B9- New Paper Mill

RESPONSE TO SUBMISSIONS FROM EXHIBITION OF ENVIRONMENTAL ASSESSMENT REPORT

- Modification #2 - Changes in Site Layout & Subdivision
- Final
- May 2010

Figure 3: McCauley Street Upgrade

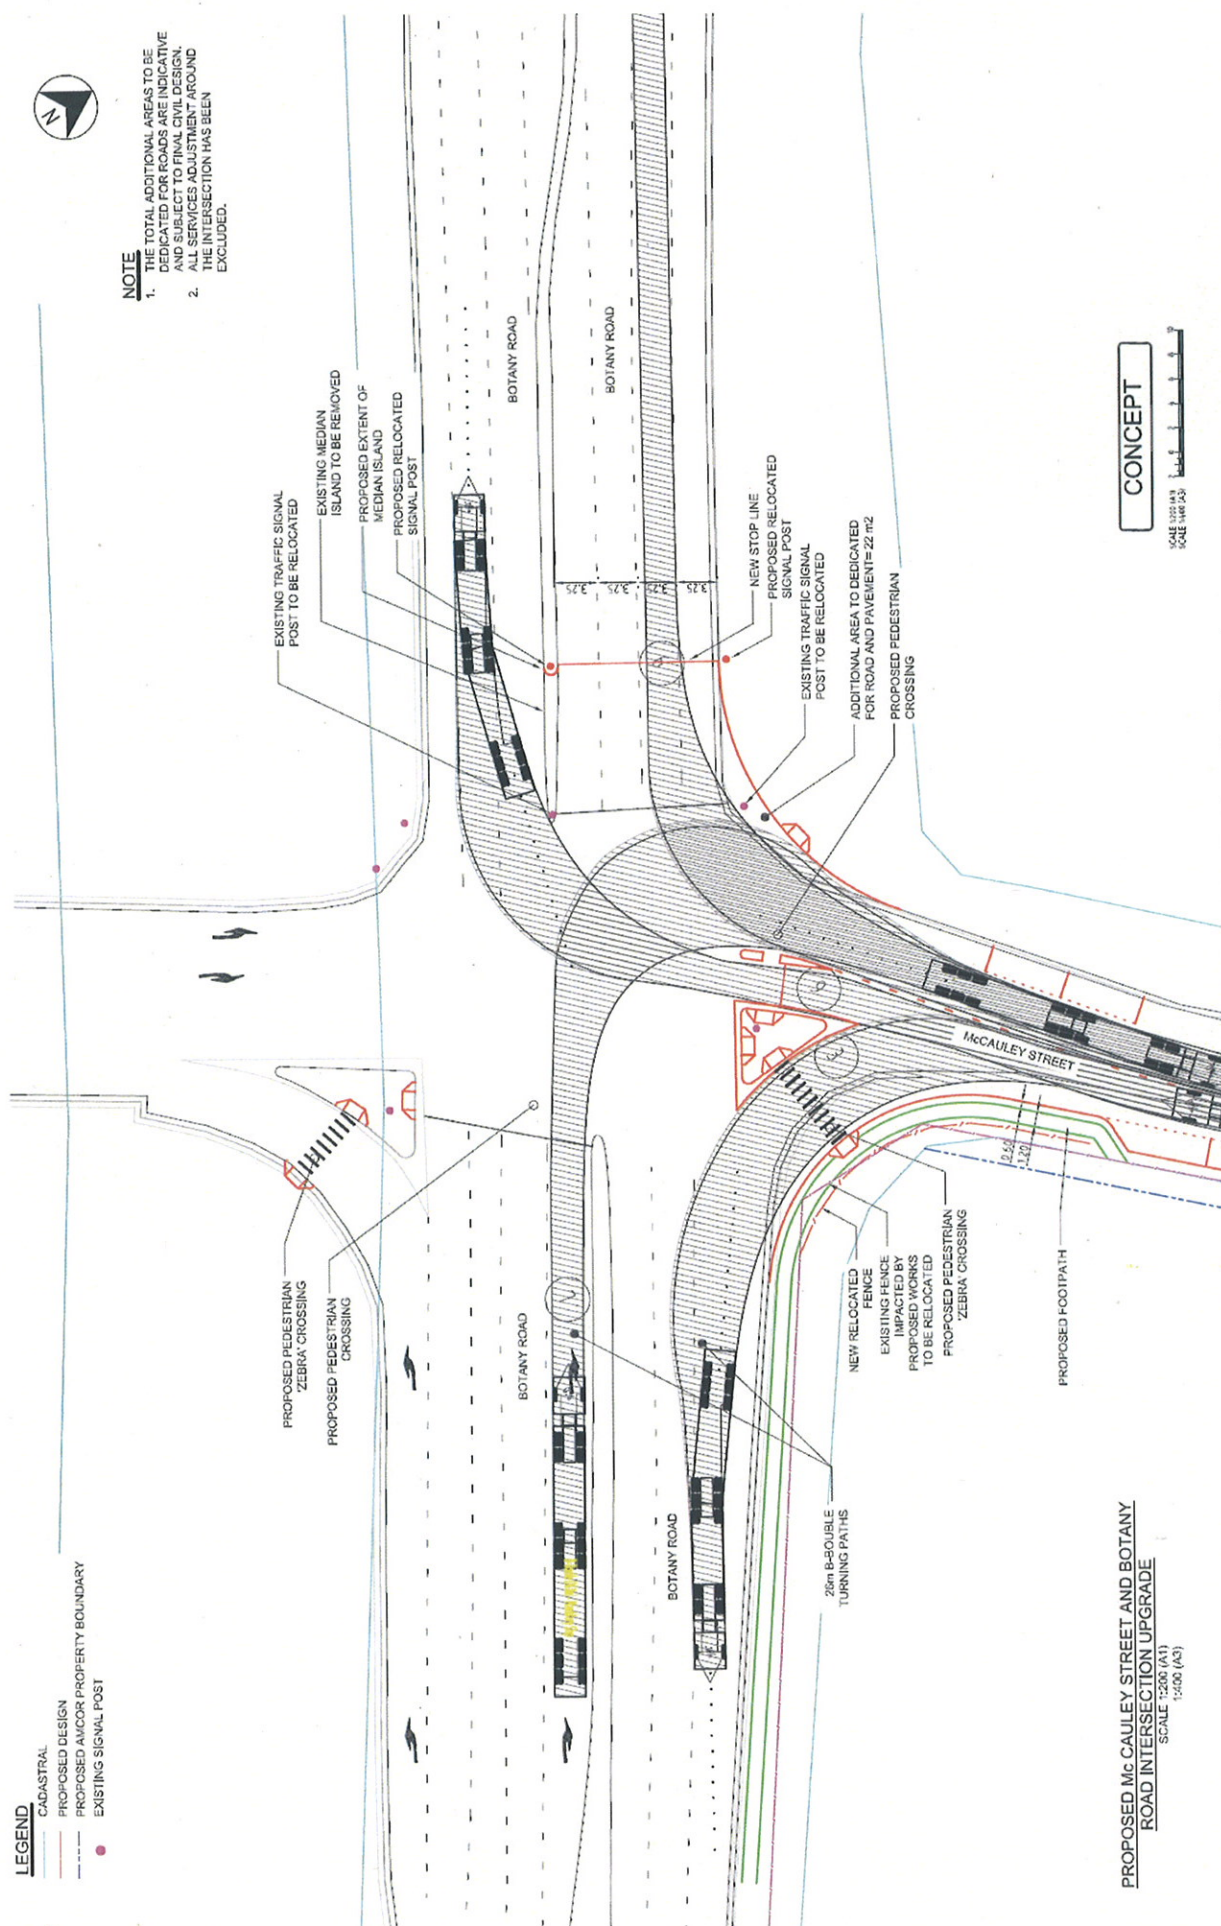
The RTA and DoP requested further details of the McCauley Street/ Botany Road intersection design including:

- Pedestrian crossings;
- Design and location of traffic islands;
- Kerb locations in consideration of semi-trailers turning into McCauley Street from Botany Road and B-Doubles turning out of McCauley Street into Botany Road;
- Dedication of land by AMCOR on the corner of Botany Road and McCauley Street for the modified intersection;
- Stage 3 Road Safety Audit by a Certified Auditor.

Appendix D shows a more detailed concept design for McCauley Street/ Botany Road intersection. All of the RTA requirements can be achieved with revised design except for the left turn into McCauley Street from Botany Road – which would have to be undertaken from a centre lane rather than the kerb lane. As AMCOR does not own the road reserve on the western corner of Botany Road and McCauley Street (or any directly adjoining land), AMCOR cannot make the commitment to undertake significant works in this area. As AMCOR operational vehicles would not be permitted to access the site from McCauley Street, any major road works to allow a left turn from Botany Road into McCauley Street should be the responsibility of RCC and/or the developer of the

The concept design shows that AMCOR would not be required to dedicate any land at the corner of McCauley Street and Botany Road as the property boundary is a significant distance from the existing and proposed kerb lines. However, if the detailed design required additional dedication of land for the intersection, AMCOR would dedicate the required land within reason.

Figure 3: Proposed McCauley Street Access Changes

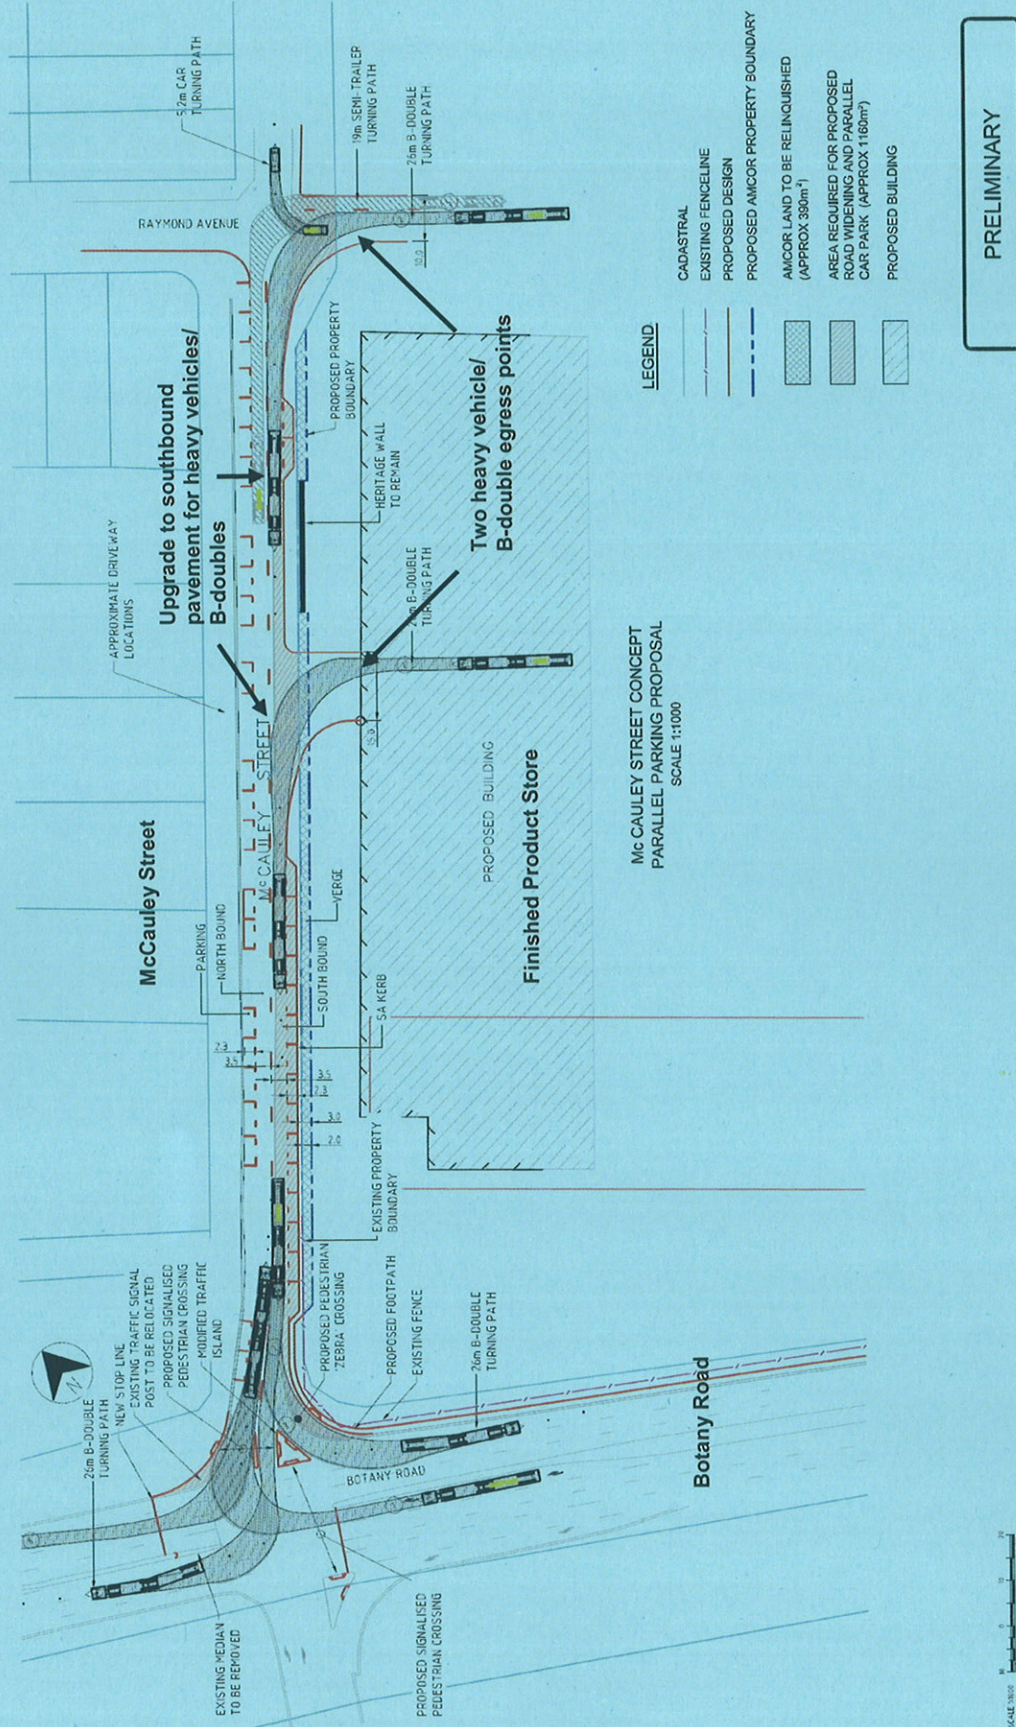
Submission #1 commented on Figure 3 of the Modification #2 Environmental Assessment Report that shows a 5.2m vehicle turning right on to McCauley Street from the proposed access at McCauley Street/ Raymond Avenue. This traffic movement was placed on the figure at the request of one of the government stakeholders and is a legal traffic movement. However all of AMCOR's vehicles would turn left only out of the site onto McCauley Street.

AMCOR recognises that additional physical measures may be required to ensure that traffic leaving the site turns left only on to McCauley Street. It has committed to consulting with RCC and the RTA in the preparation of the detailed design of McCauley Street to ensure that appropriate physical traffic measures (e.g. signage, traffic barriers etc) are included. Also AMCOR would be prepared to commit to other non-physical measures such as driver education and penalties to ensure that their vehicles do not impact upon residential areas.
